**From:** John Cornell <jcornell@SageFruit.com>  
**Sent:** Wednesday, May 07, 2014 3:06 PM  
**To:** Lindsey Ozbolt  
**Subject:** RE: CU13-0007 Burbank TWHousing layout proposed parking/access change

My understanding from the description below is that the access point from Burbank Road is at the same location, you are just modifying it once you are on your parcel. If my statement is correct, then I do not have an issue with this change in configuration of parking/drive area as long as Fire Marshall and Public Works are good with it. We will need a new site plan for the file showing the change.

SITE PLAN

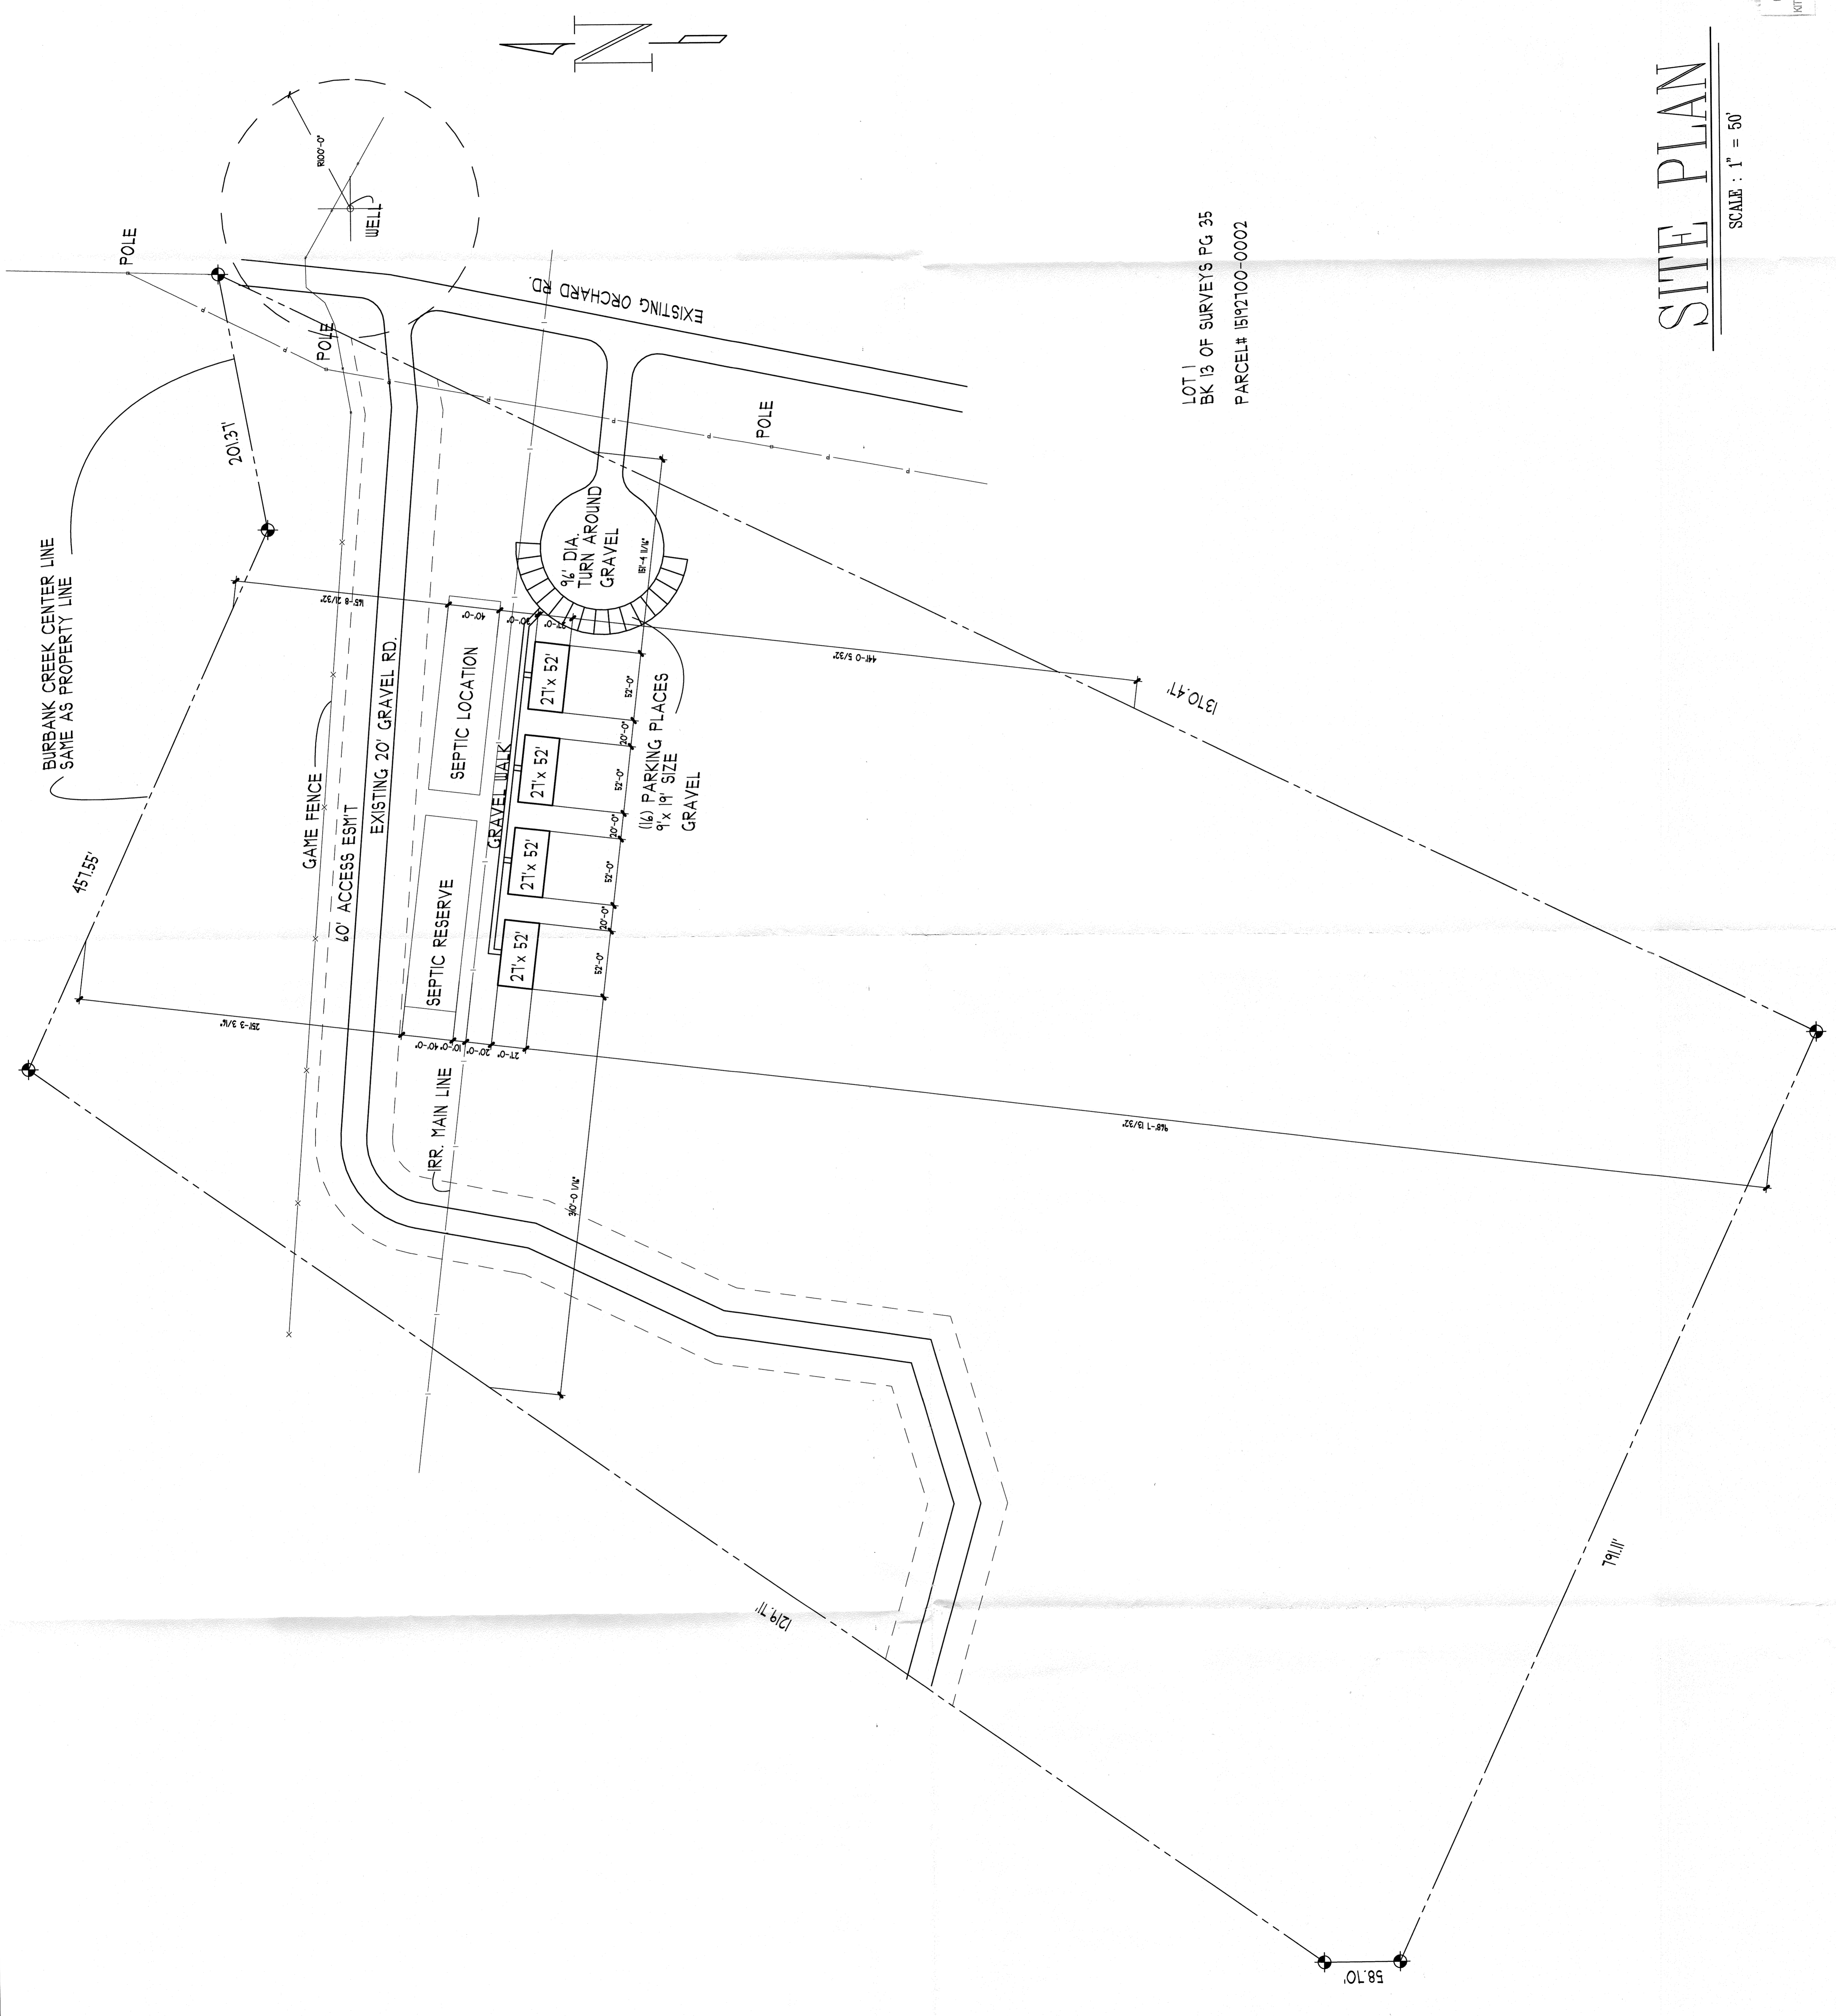
As per our conversation yesterday, I've attached the contractors' two options to alter the parking/access to improve it for all concerned. Instead of this humungus gravel circle(incl. the proposed parking 'spaces', the contractor is proposing in both options to just put in an access road clear across the south side of the side, so traffic/access can flow with no need to turn around, and each unit can be more easily reached by EMS. His additional benefit is that it will automatically provide a barrow ditch on the up hill side to direct runoff around the foundations and lawn areas around the units.

Option #1 overlayed on the CU site plan assumes each unit will have a 20' x 20' apx. Area from proposed road to back door for access and parking,

Option#2 all hand drawn, shows the graveled area, again apx. 20' by 20' located Not butting into the back steps but between the units, with future concrete side walk providing walking access to front sidewalk.

I am not sure if that will suffice or not John. If you have the as-built and want to forward it to me, I can let you know. It needs to be similar to the site plan showing the affected area: property lines (at least for the northern area of the property), road area, parking, and farm housing units.
